Recommendation Report for Planning Permission for Works or Extension to a Dwelling

REF NO: LU/136/14/HH

LOCATION: 34 Wick Street
Littlehampton

PROPOSAL: Drop kerb & vehicular access. This application may be determined by Littlehampton Town Council under delegated powers

Ref 2

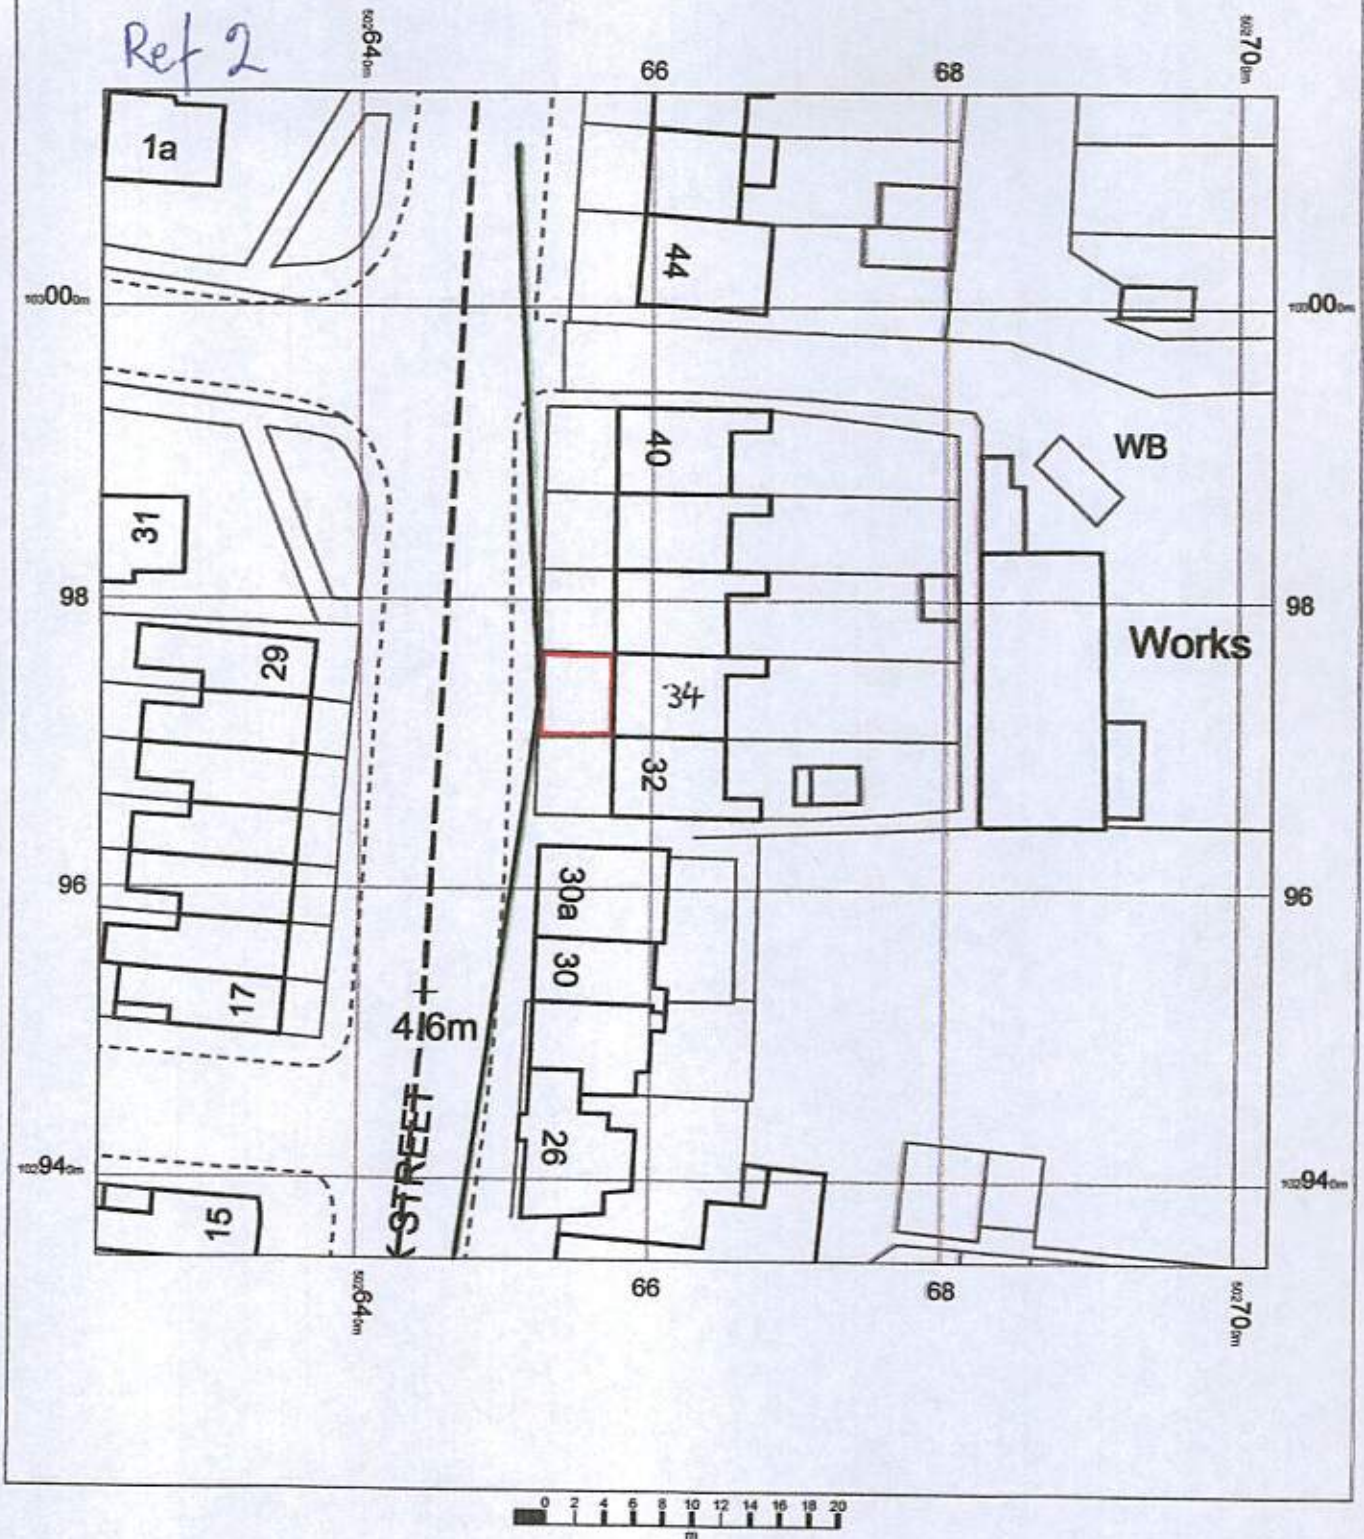
No concerns from the highway point of view. If the LPA are minded to approve this application a condition securing the new access and pedestrian visibility splays should be included.

- 3 The proposed vehicular access shall not come into use until the visibility splays shown on the 'Visibility Plan' (Ref 2) have been provided and thereafter retained and kept clear of any obstruction greater than 0.6 metres in height.
